## Application by National Grid Electricity Transmission for the Norwich to Tilbury project

### The Examining Authority's written questions and requests for information (ExQ1): Issued on Friday 22 May 2026

Document: 7.4 Outline Landscape and Ecological Management Plan
Appendix F - Bird Diverter Locations

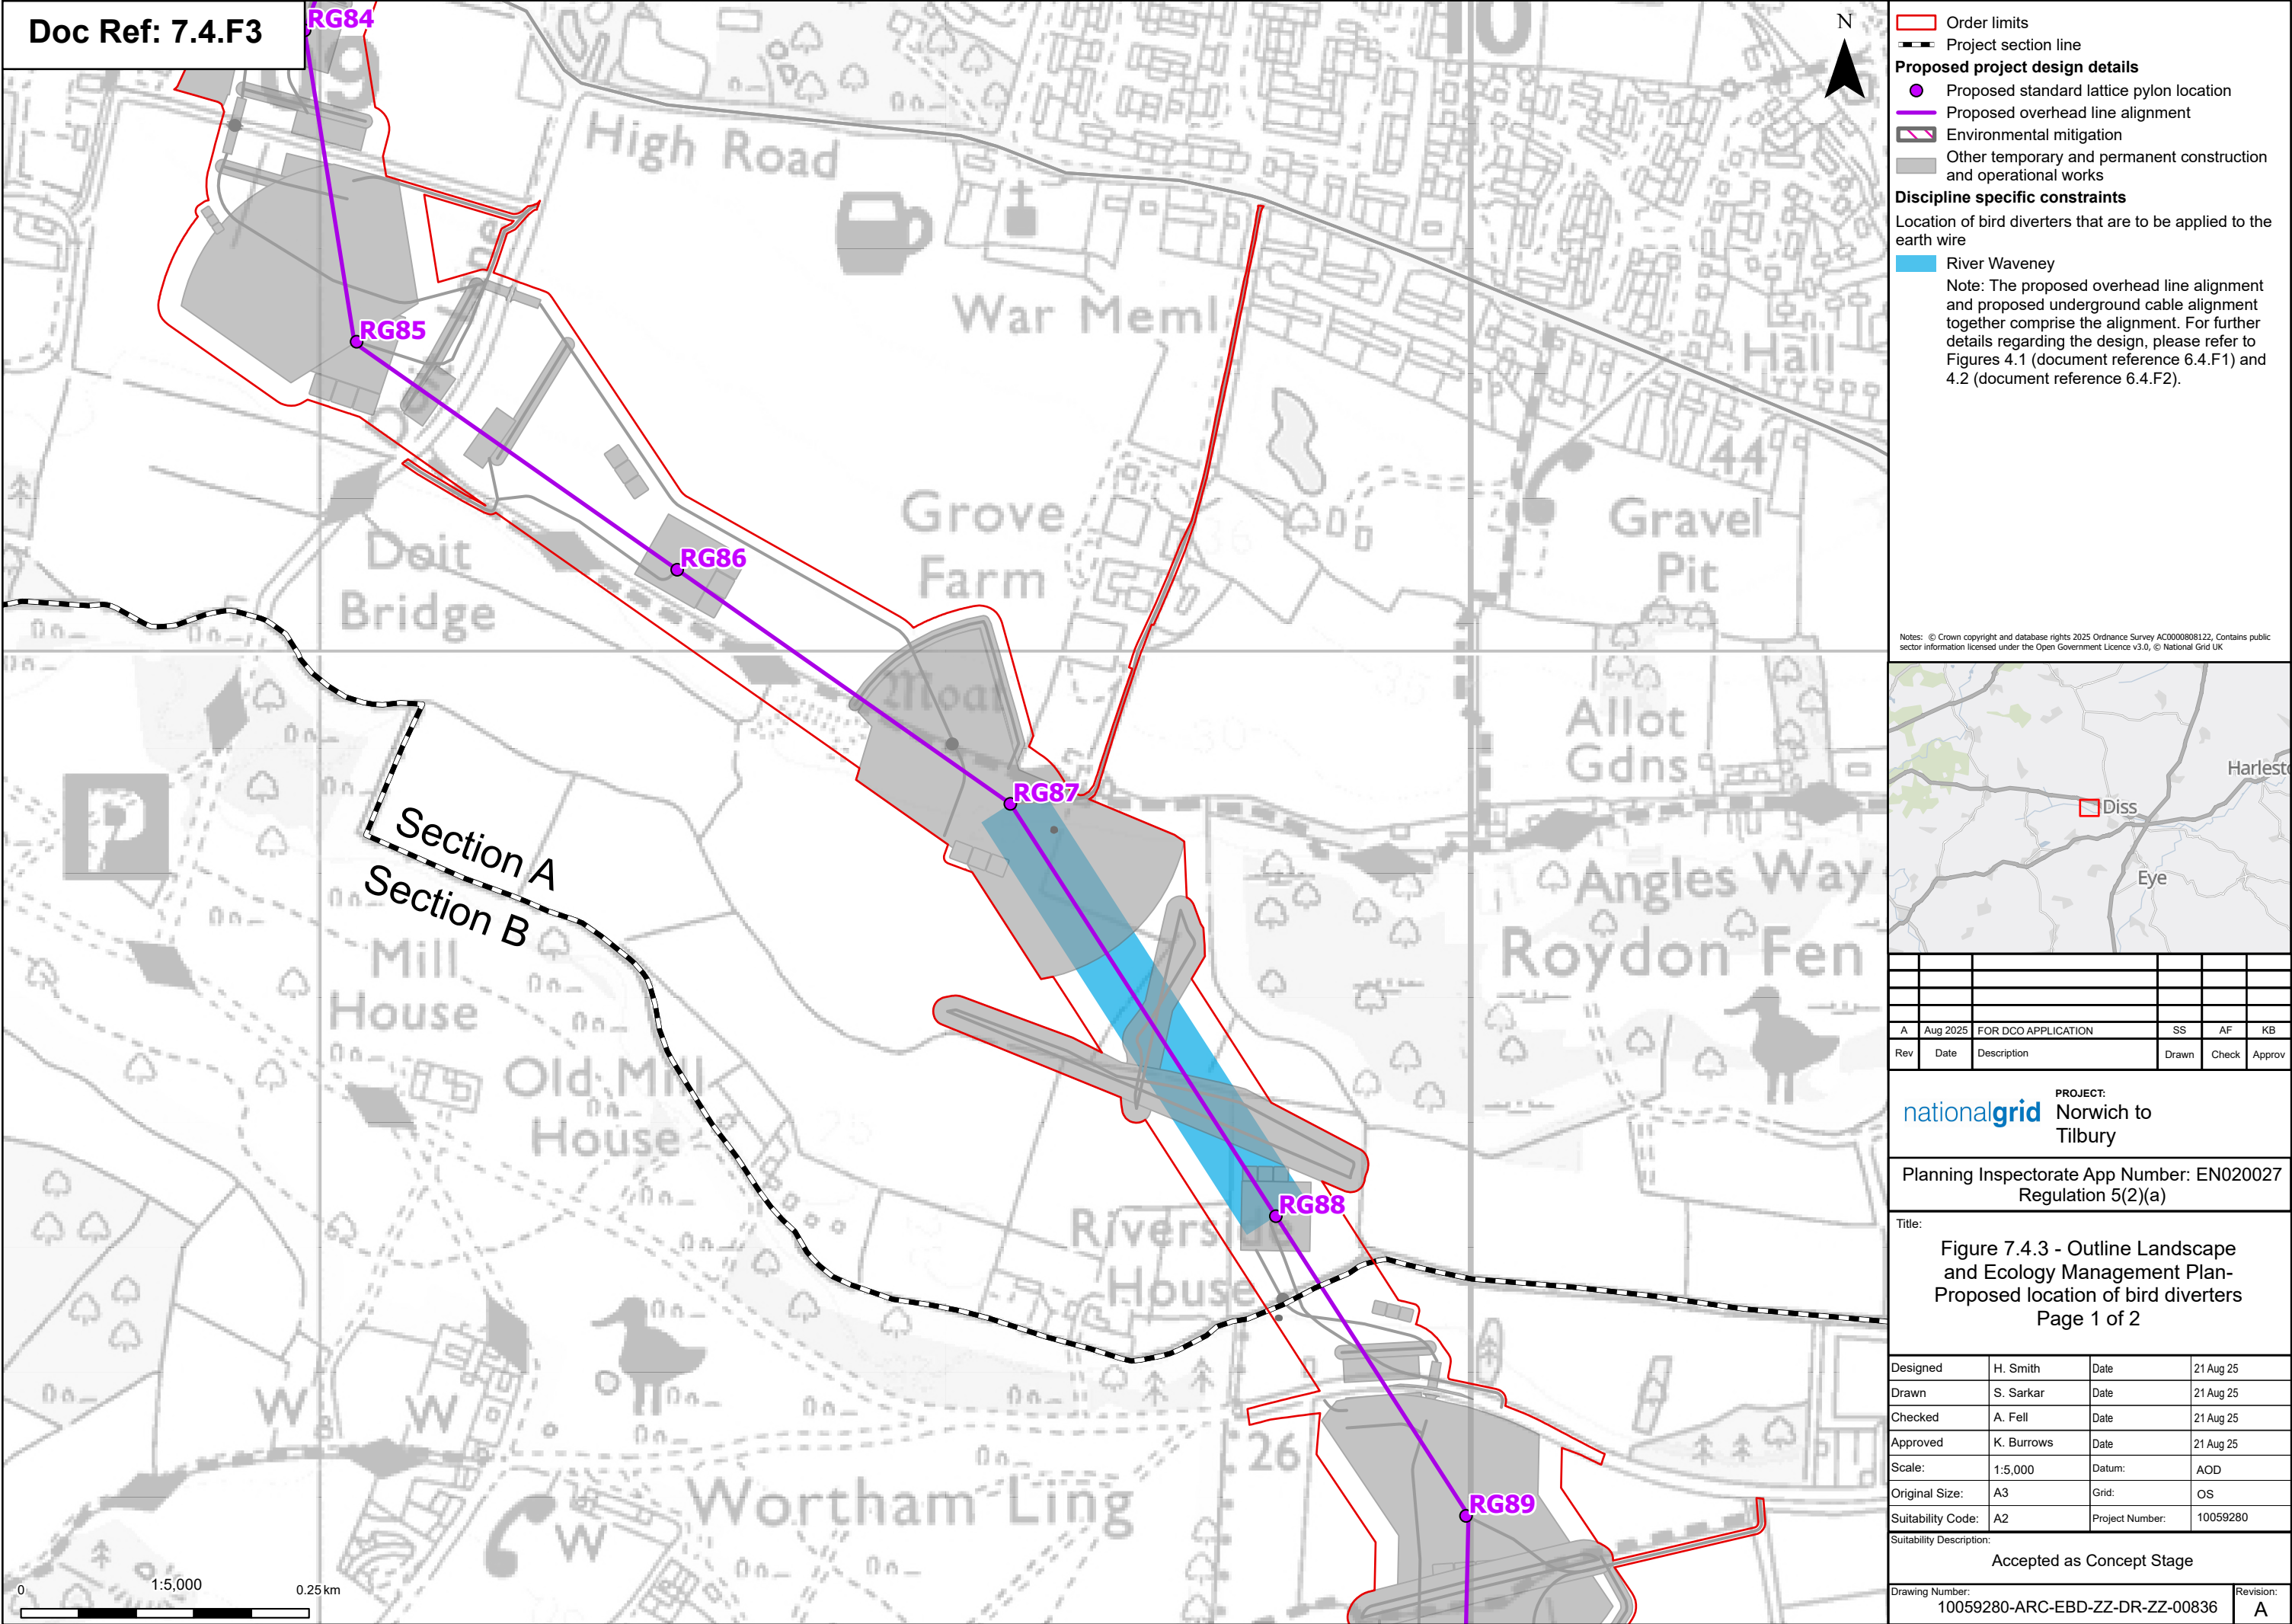
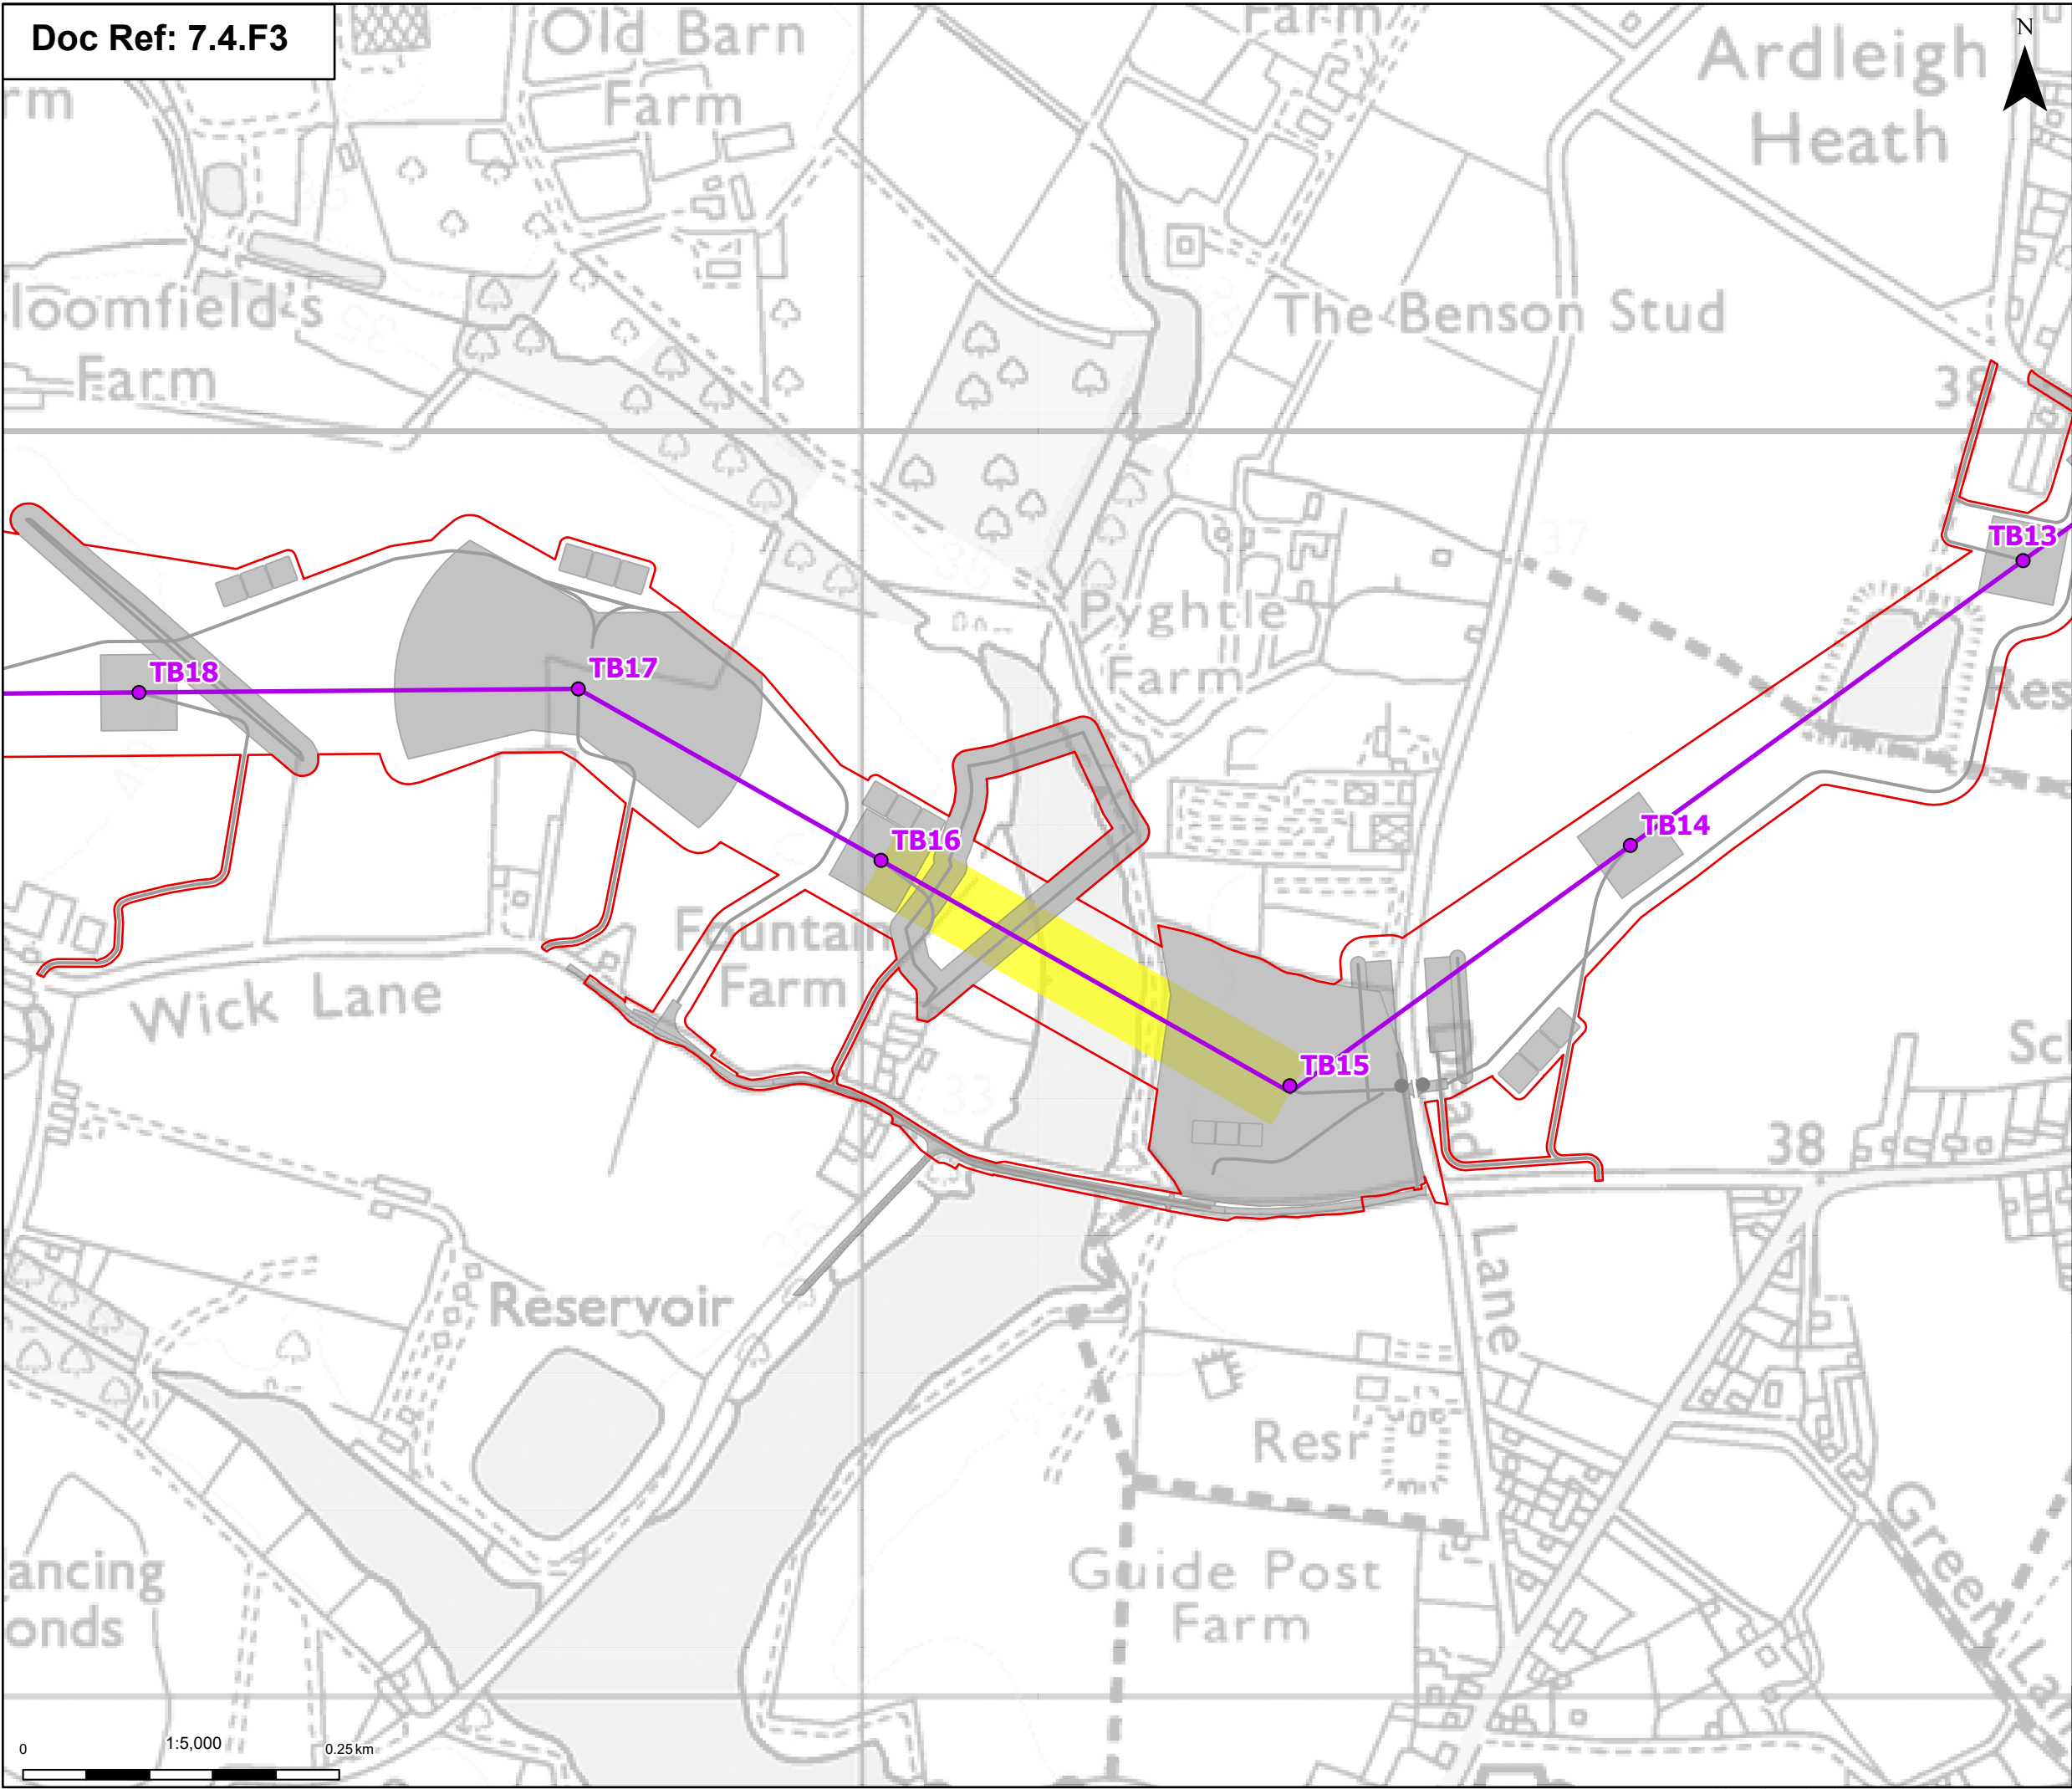
<p>BIO 2.8</p>	<p>All local authorities          Norfolk Wildlife Trust          Suffolk Wildlife Trust</p>	<p><b>Monitoring the effects on birds</b></p> <p>In response to ExQ1 BIO 1.13 regarding the use of bird diverters the applicant in <a href="#">[REP3-074]</a> states that ES Chapter 8 <a href="#">[AS-026]</a> and the Habitat Regulations Assessment (HRA) Report <a href="#">[APP-082]</a> predict no significant adverse effects on birds during operation of the proposed development either with or without mitigation and therefore additional monitoring or adaptive management is not considered necessary or proportionate. Do you agree with the applicant's comments in this regard, if not then please explain why and set out what additional monitoring and (if necessary) adaptive management you would wish to see secured.</p> <p><b>SNDC Response</b></p> <p>The conclusion of 'no significant adverse effects' of the shadow HRA relates to the Stour and Orwell Estuaries SPAs and Ramsar site, rather than impacts on birds in the River Waveney area. It is a matter of fact that birds will collide with the earth wire and conductors.</p> <p><a href="#">[REP3-074]</a> advises that bird diverters are proposed at two locations including over the River Waveney in South Norfolk -between pylons RG87 and TG88 (see Outline Landscape and Ecological Management Plan, Appendix F – Bird Diverter Locations <a href="#">[APP-327]</a>). The use of bird diverters at the R. Waveney is precautionary because works associated with Waveney and Little Ouse Recovery Project (WaLOR) are expected to improve habitat in this area and become more suitable for waterbirds in the future.</p> <p>The effectiveness of bird diverters at preventing collision risk by birds varies depending on the type of diverter used (with the flapper flight diverter performing best in one study<sup>4</sup>) but it is widely accepted that flight diverters generally lower mortality rates (one study suggests by 52% compared with unmarked spans (see <sup>1</sup>)). A proportion of birds will continue to collide with the spans even with the use of bird diverters.</p> <p>We would suggest that National Grid are asked to provided further details with regards to: which type of bird diverter will be used; how close they will be placed (e.g. every 5 m); and details of maintenance. We would also seek clarification as to whether bird diverters will be placed on the ground wire as well as conductors.</p> <p>With regards to monitoring Bird Strike Indicators<sup>5</sup> could be used to monitor bird collisions assuming they can be installed and replaced without causing additional damage to habitats (see <a href="#">5.10.2. Measures to reduce risks caused by powerlines - Biodiversity &amp; infrastructure handbook</a>). Because birds will hit the conductors and earth wires the aims of the monitoring would need to be clear e.g. at which threshold would remedial action be taken, and what would this look like (e.g. increasing the density of the diverters). The cost of monitoring bird collision in the two proposed locations would not be significant, and should further mitigation be required because habitats along the R. Waveney becomes more suitable for water birds, any measures would serve to further reduce bird mortality.</p>
